Your ref:  
Our ref: 23/00276/F  
Please ask for: Amy Davies  
Direct dial: 01553 616879  
E-mail: borough.planning@west-norfolk.gov.uk

Details: **Extension of dwelling and conversion of detached garage to create annexed accommodation. at Hall House 4 Commonsides West Winch Norfolk PE33 0NJ**

I have received a planning application as detailed above but cannot process it until I receive some more information:

First Floor Plan (1:50)

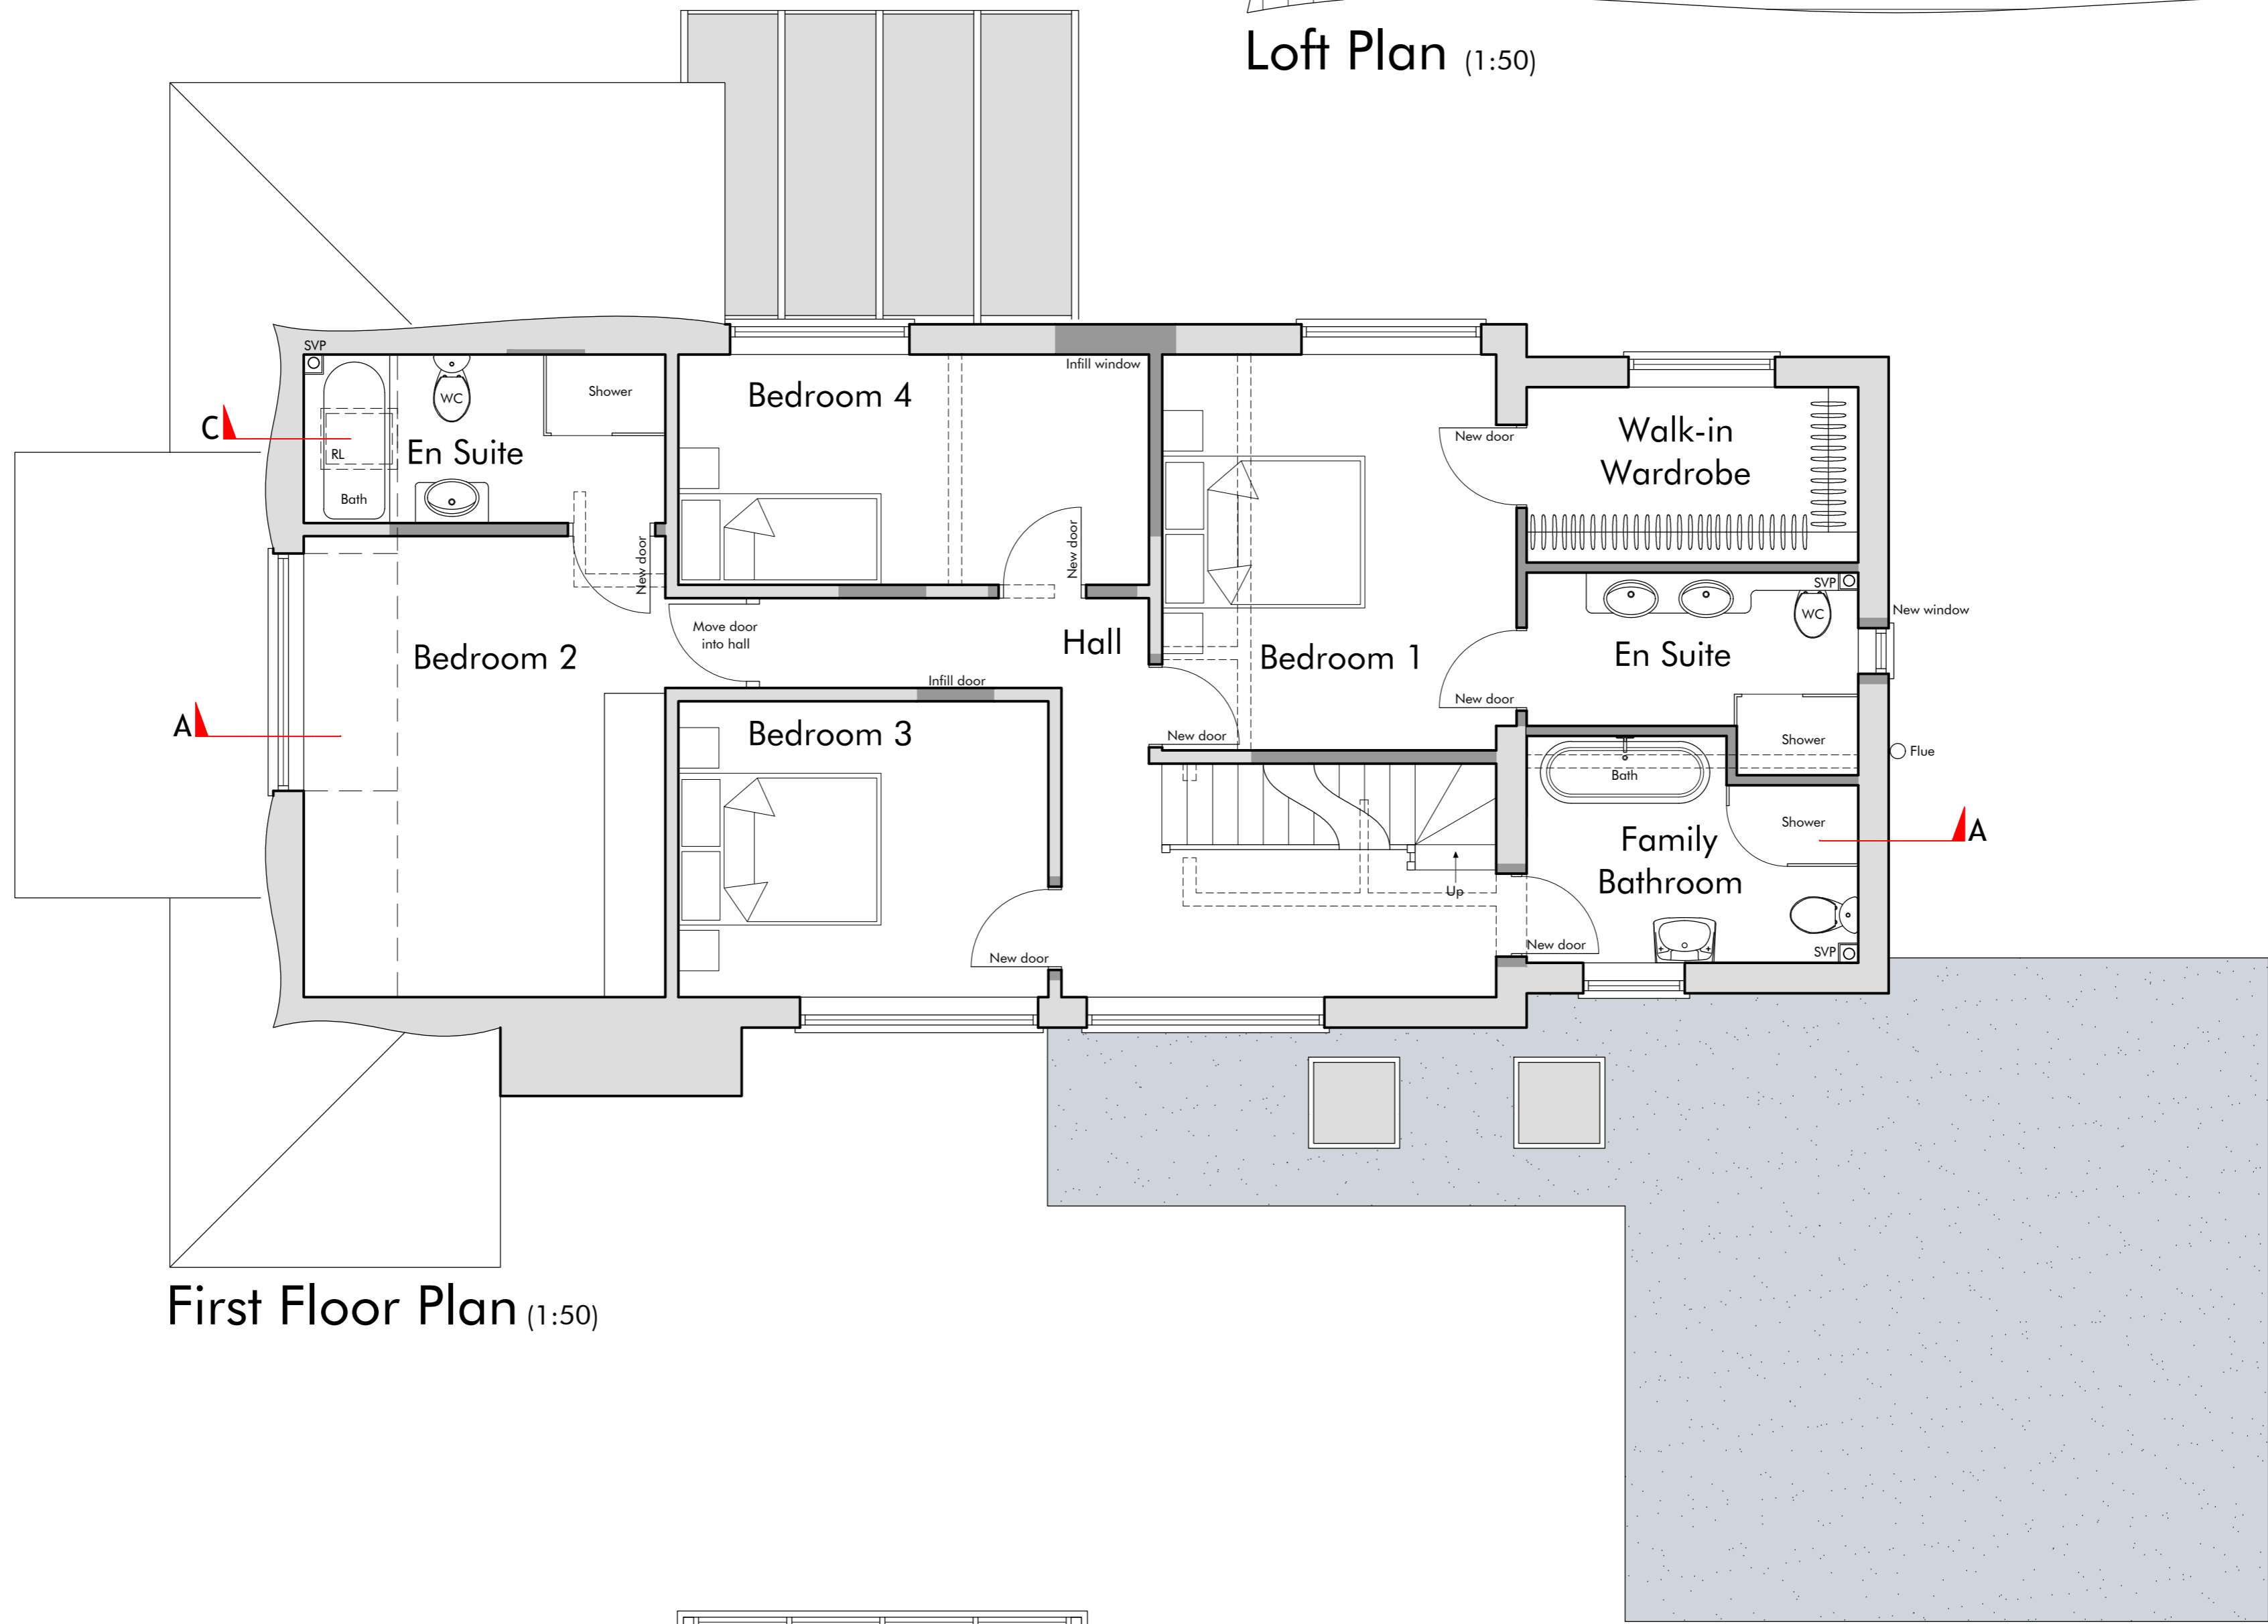
1. Please can you specify what the annex is being used for as a habitat fee may be required .
2. It appears on the south elevation (plan 3/430/4C) is showing a window on the first floor but it doesn't seem to be showing on the first floor plan (plan 3/430/3C) please amend and resubmit.
